# **A46 Newark Bypass**

**Scheme Number: TR010065**

## **Statement of Common Ground with Newark and Sherwood District Council 'NSDC'**

**February 2025**

Drawing file: TR010065 / TR010065-000155-TR010065_A46 Newark Bypass_6.2 Figure 2.3 Environmental Masterplan.pdf

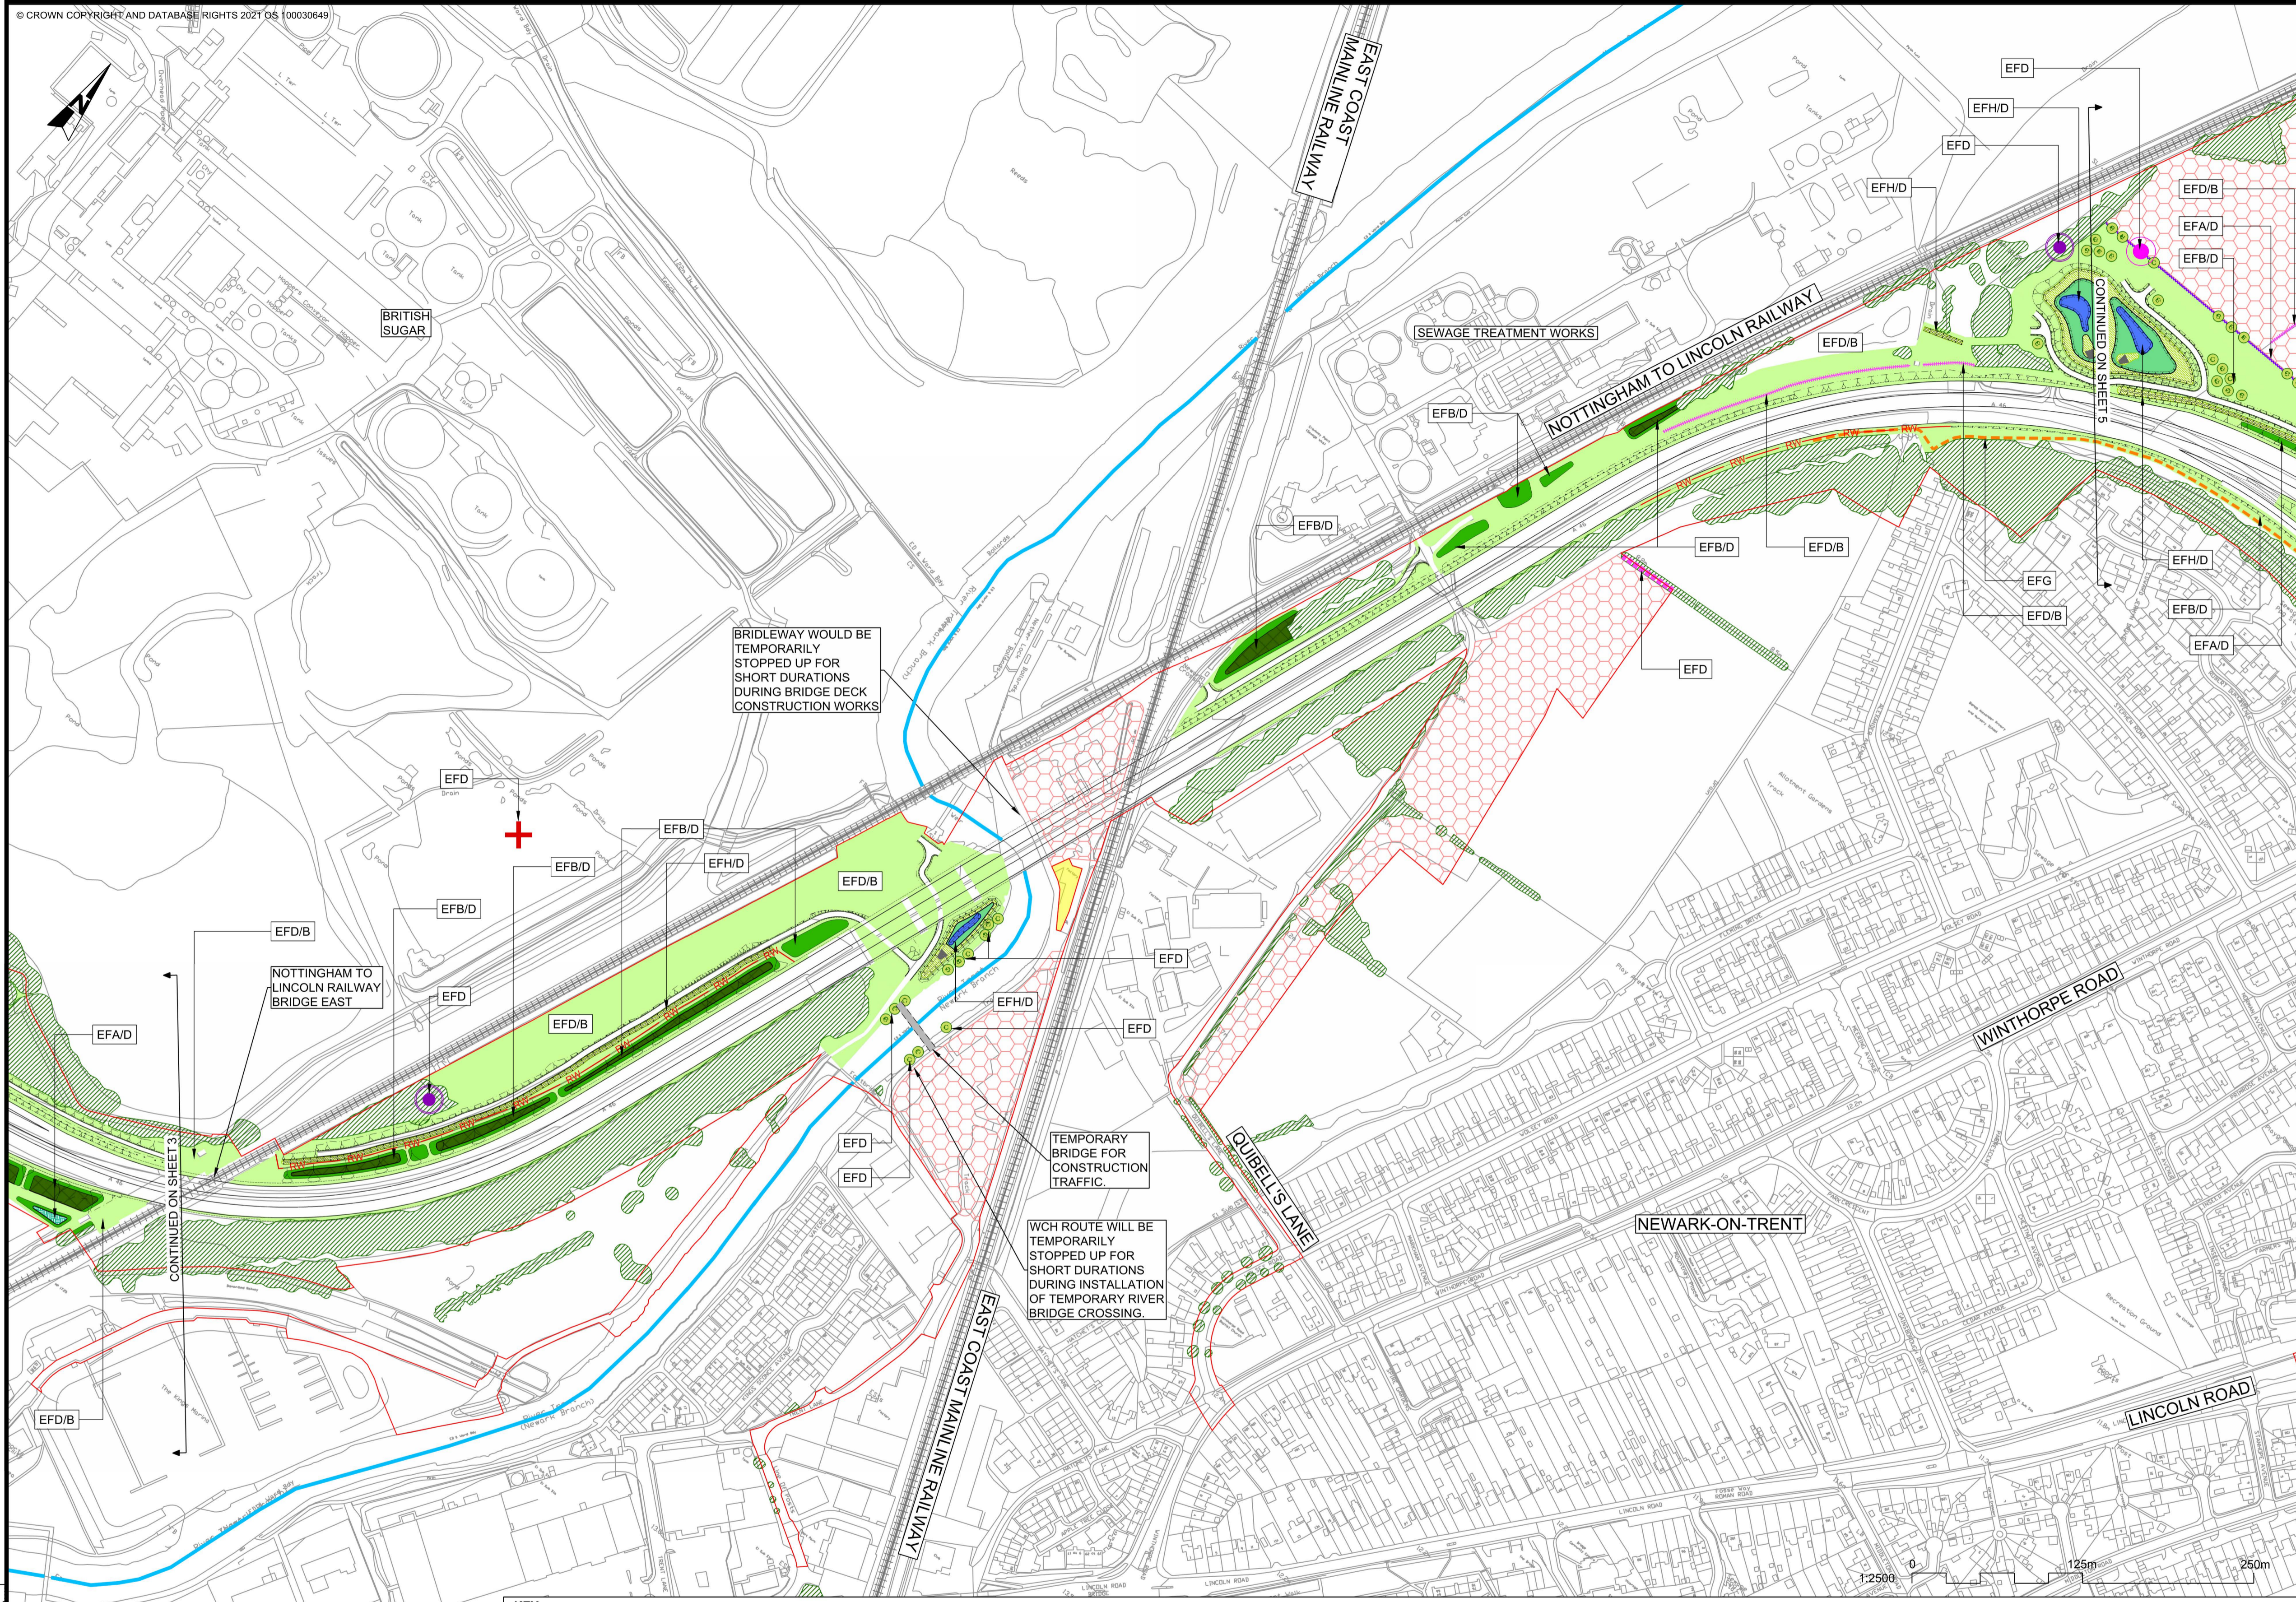
12.	Design (including justification for any flexibility being sought)	Chapter 2 The Scheme of the Environmental Statement [APP-046]  6.2 Environmental Statement - Figure 2.3 Environmental Masterplan [AS-026]	<b>Cattle Market flyover</b>  On the fly-through video the structure of the elevated over-pass at the Cattle Market junction appears as a stark and imposing concrete structure. This may be in part due to the animation which depicts it as being very bright in colour and therefore standing out vividly. The Council would want to understand proposals to ensure the visible impact of the final structure is minimised and/or mitigated as far as practicable.  03/02/2025 – Although this structure is now understood we still continue to raise concern with the impact the structure would have on the surrounding area.	Consideration has been given to the aesthetic finish of the structure during the design development to help to reduce the visual prominence of the structure and to reflect finishes on existing structures such as that of Smeaton's Arches just to the north of the new junction. Further details of these can be found within Chapter 2 The Scheme of the Environmental Statement [APP-046] and 6.2 Environmental Statement - Figure 2.3 Environmental Masterplan [AS-026].  Planting of trees and shrubs has also been considered and incorporated wherever feasible to help break up the visual mass of the structure, with planting softening the built form and aiding screening over time, particularly from properties such as those in Sandhills Park affording near distance views.  The assessment of landscape and visual effects and associated design and mitigation measures are described in 6.2 Environmental Statement - Figure 2.3 Environmental Masterplan [AS-026] and presented in 6.2 Environmental Statement - Figure 2.3 Environmental Masterplan [APP-026].  Part of the Detailed Design process will be to define the finish of the retaining walls forming the Cattle Market Flyover. This will be a masonry type façade and not a bare concrete finish.	Not Agreed	20/02/2025
